**Re: PA22-042 – Sunnyside Village Co-Housing – Technical Review 1**  
3121 66<sup>th</sup> Ave NE – APN: 29050300402100

**PRELIMINARY SUBDIVISION / CUP COMMENTS**

B1 COTTAGE B - COLOR ELEVATION - SIDE B  
1/4" = 1'-0"

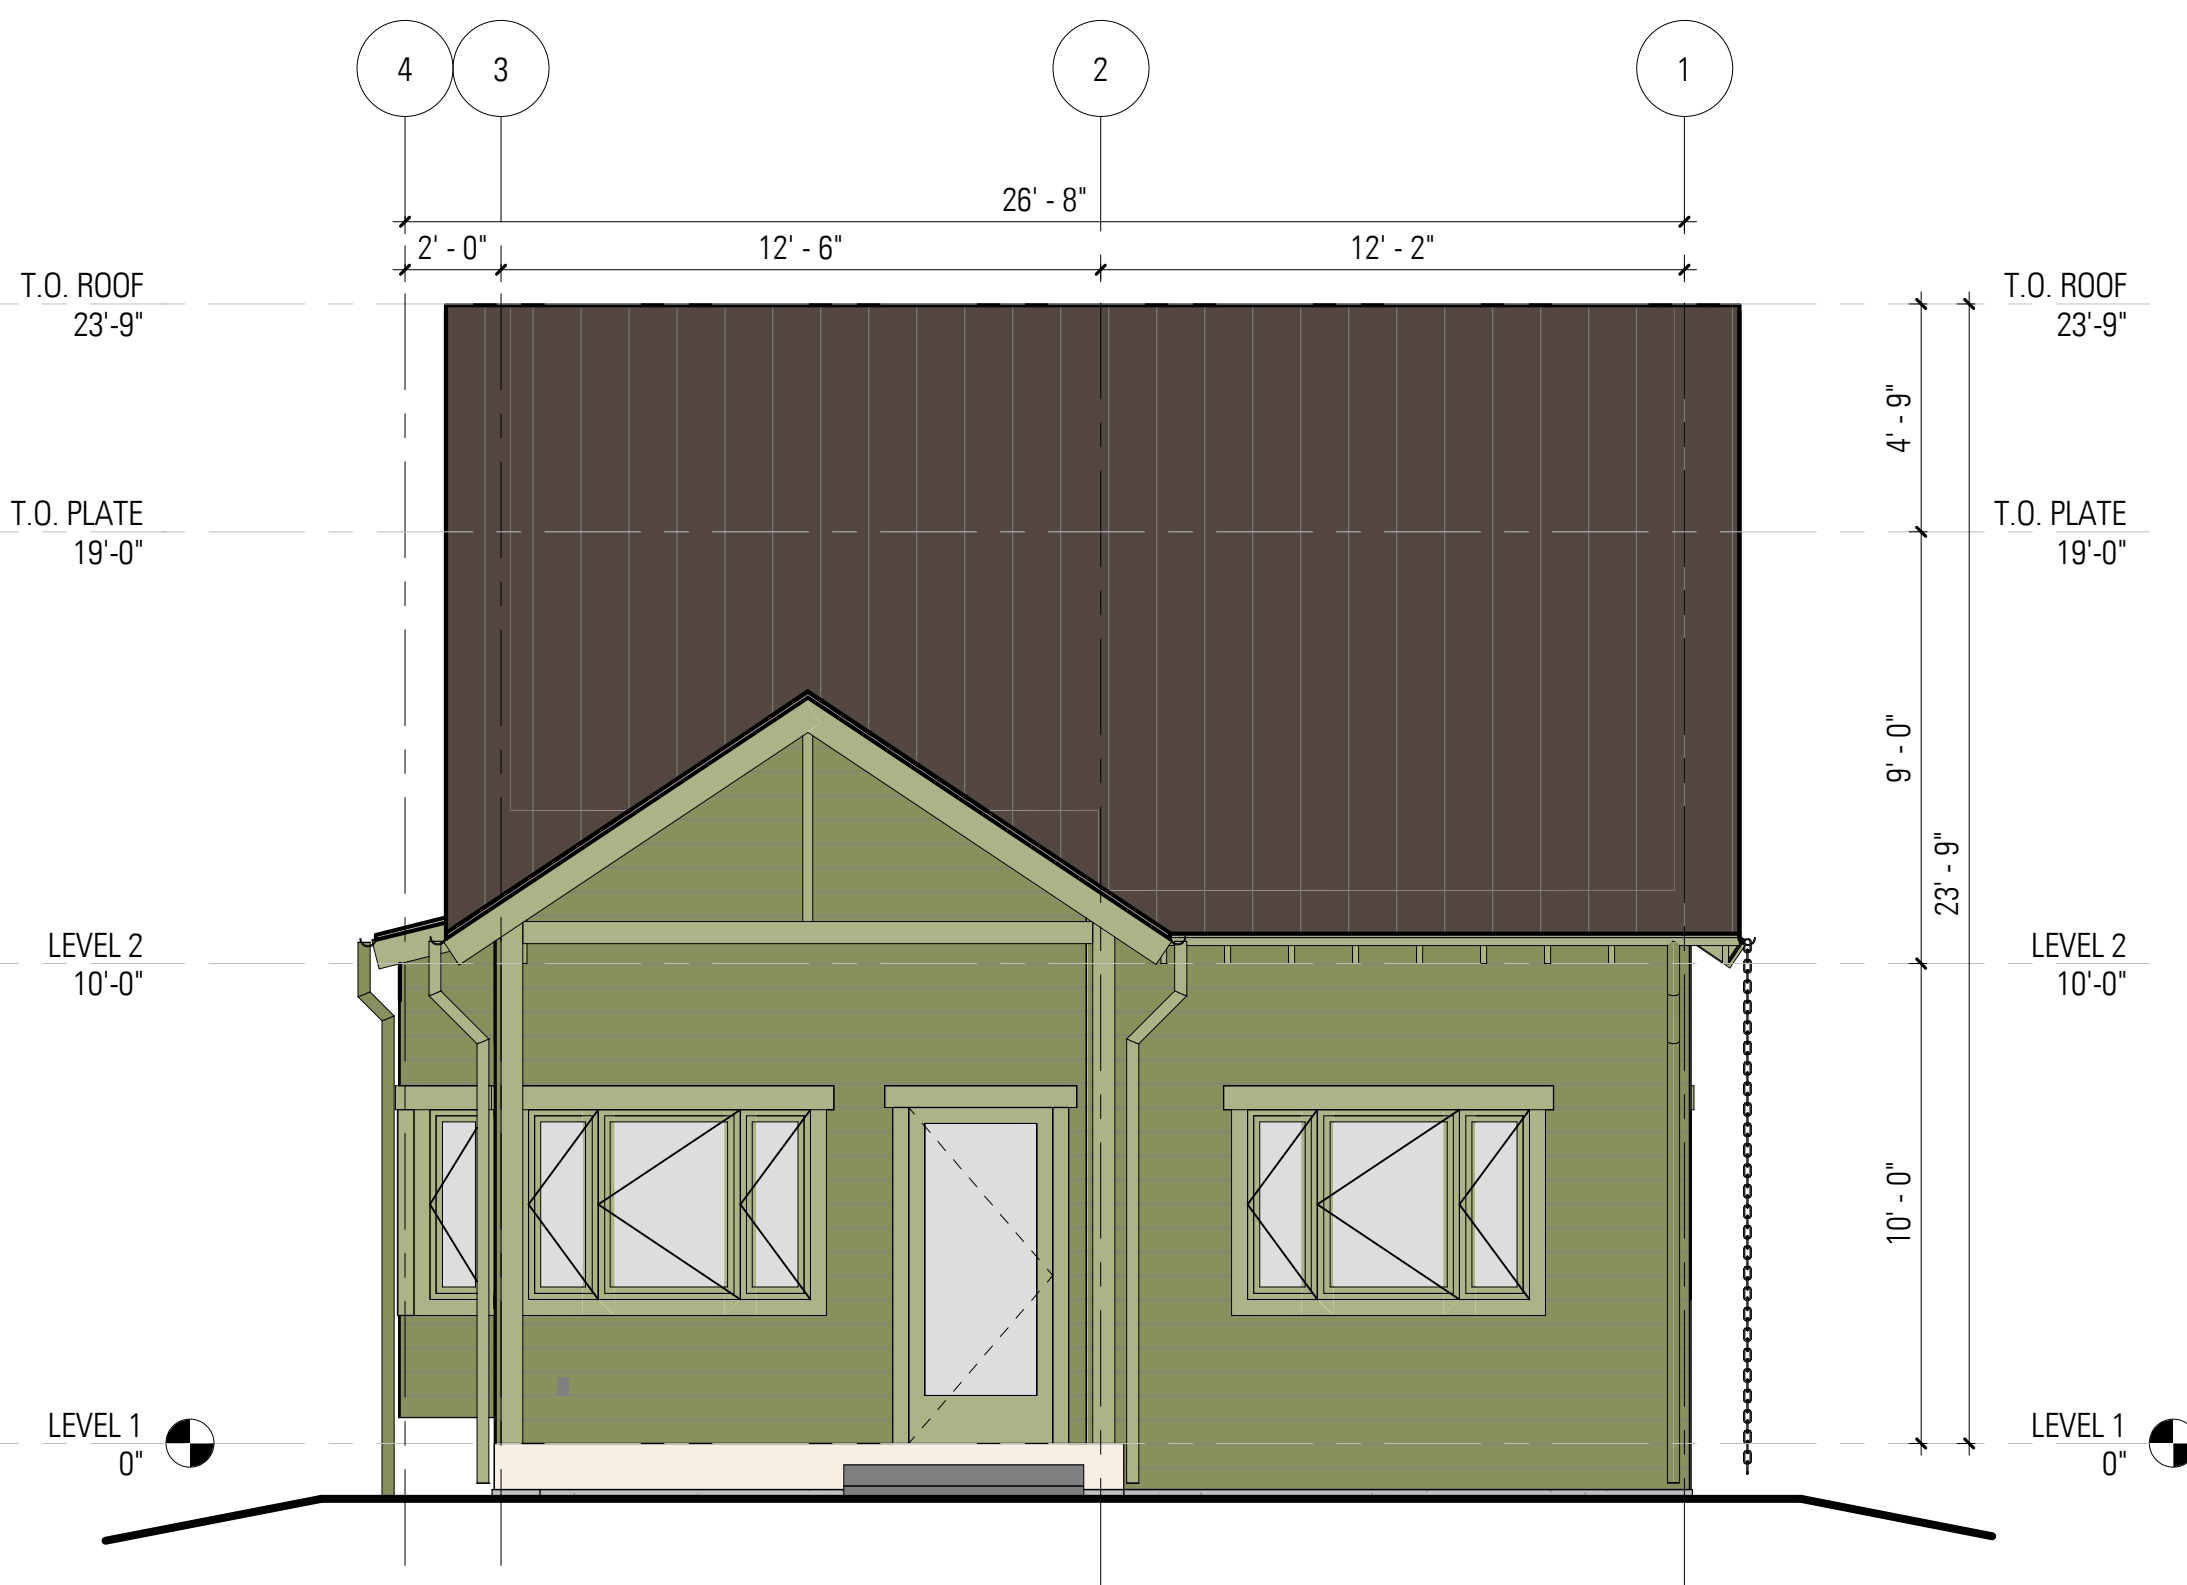
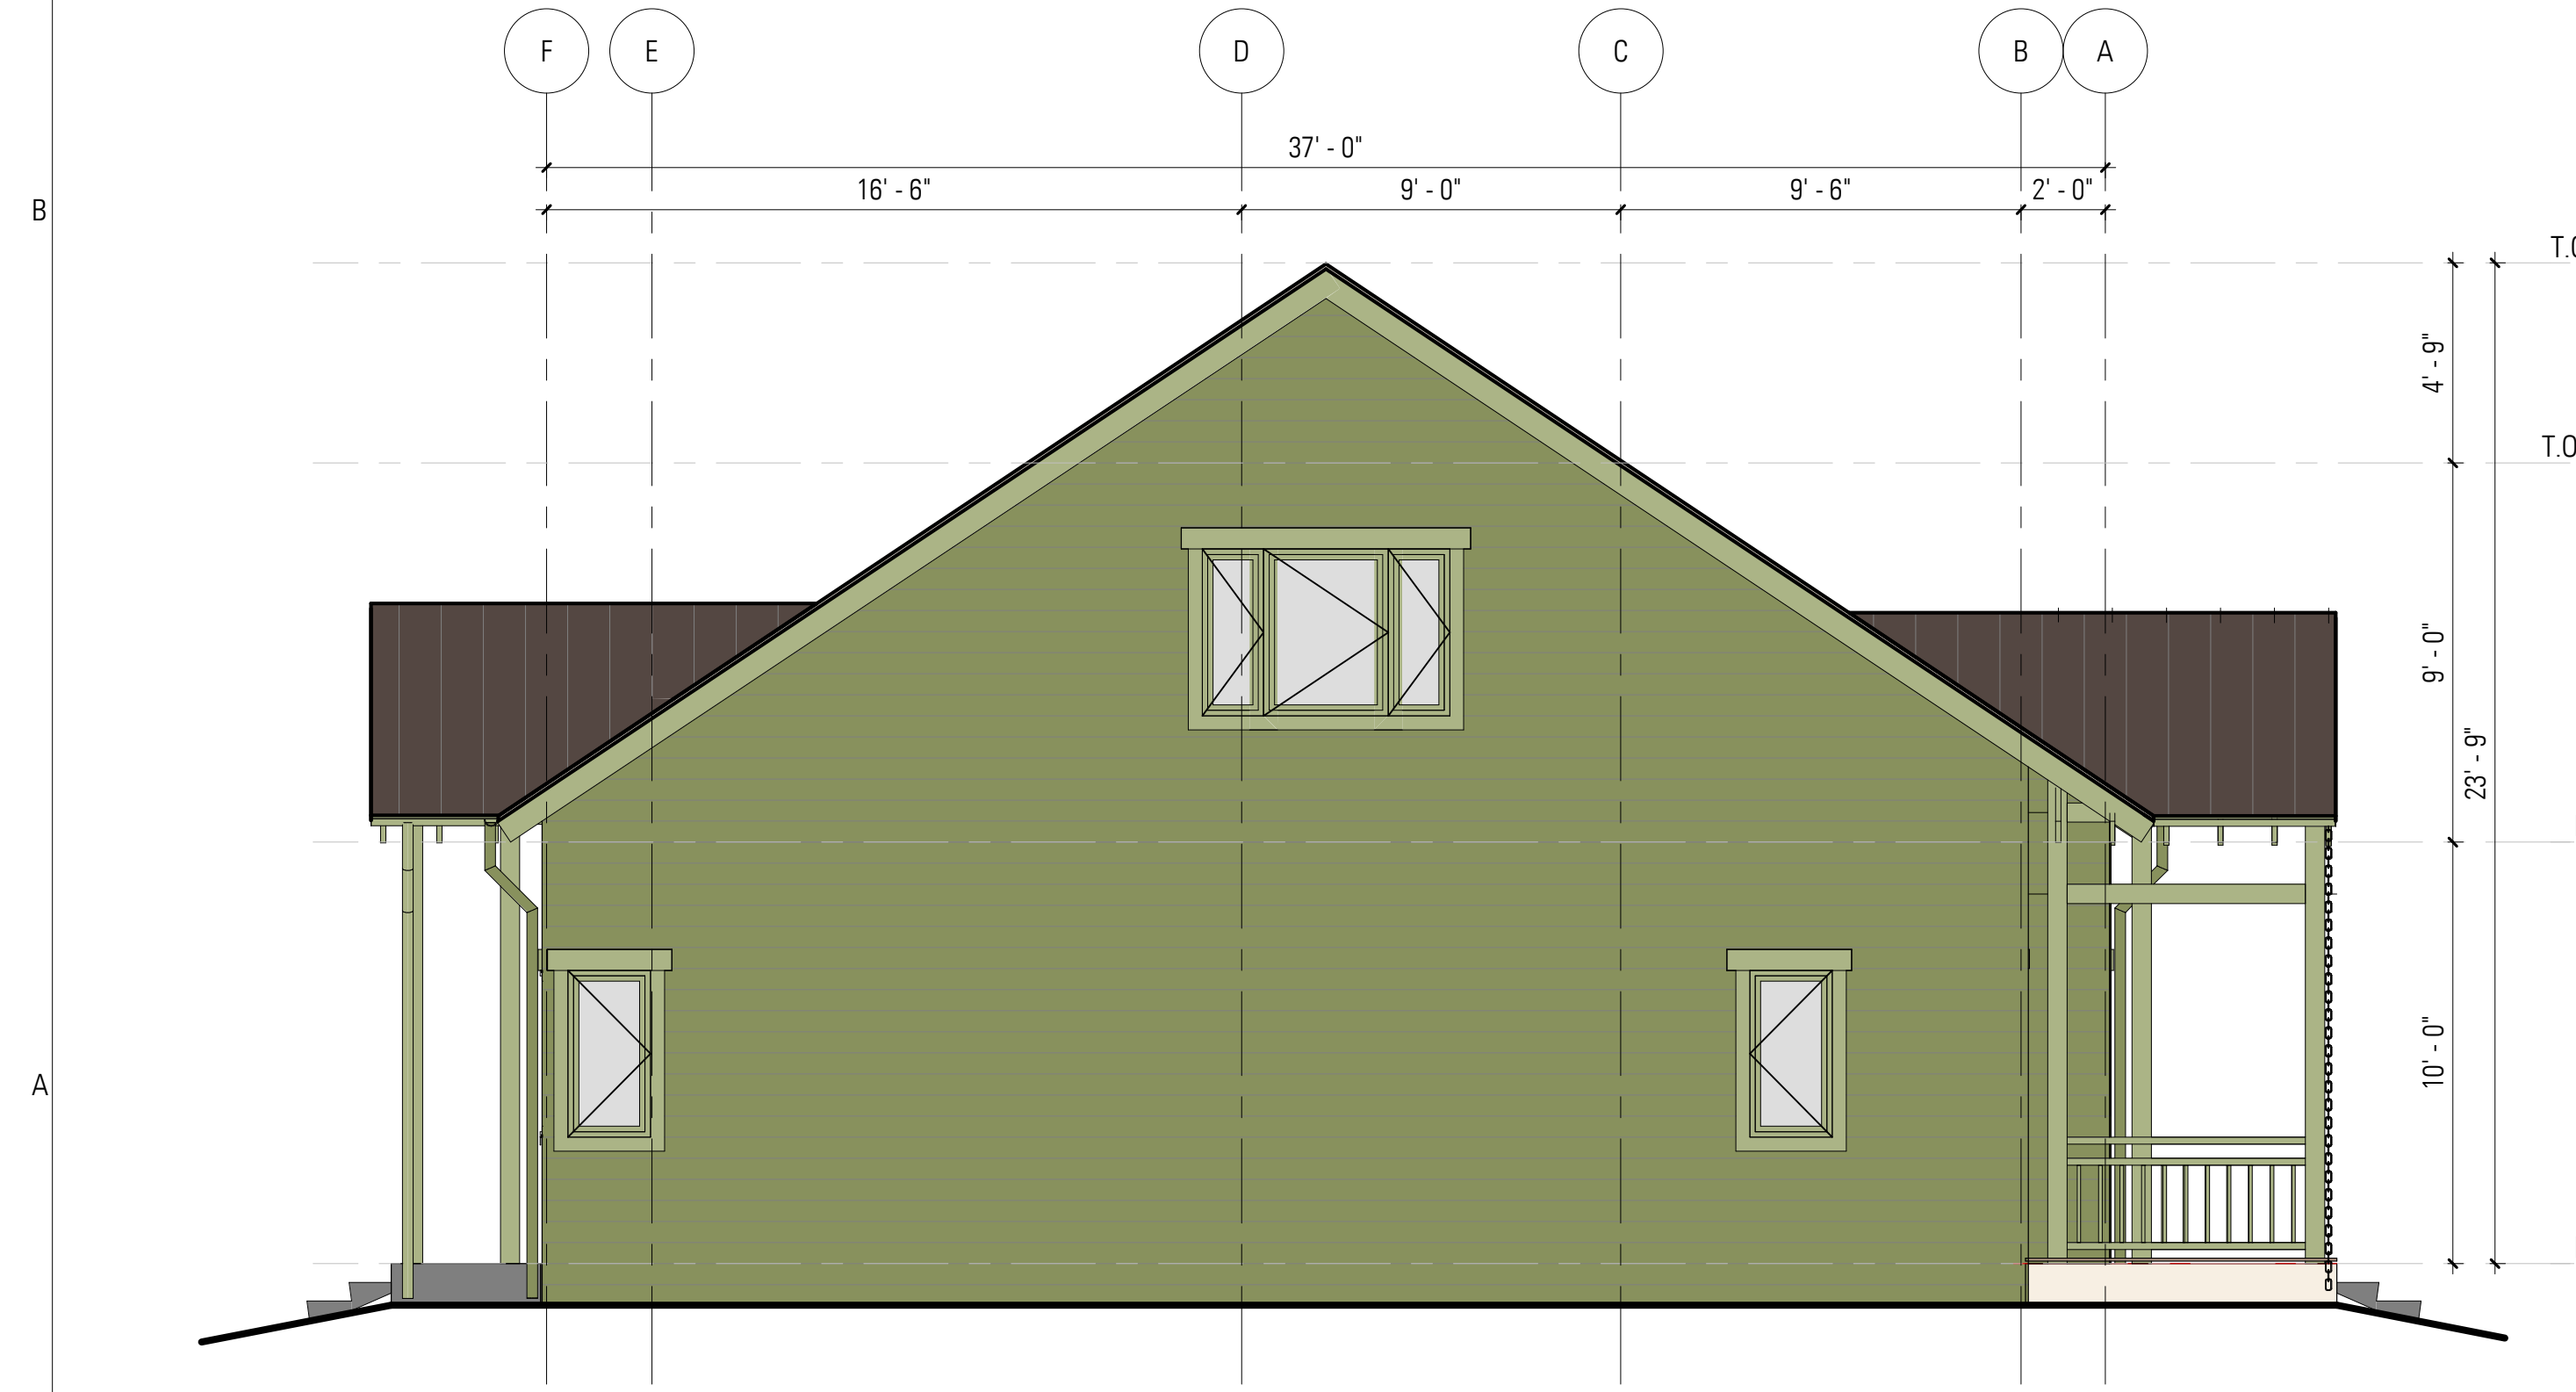
- 9. As proposed, the cottages do not appear to be visually different enough per MMC 22C.010.280(9). Proposed cottage plans A & B and C & D appear to be the same externally, with the exception of color. The cottages must offer a variety of visual interest, such as different roof forms, window design and entries.
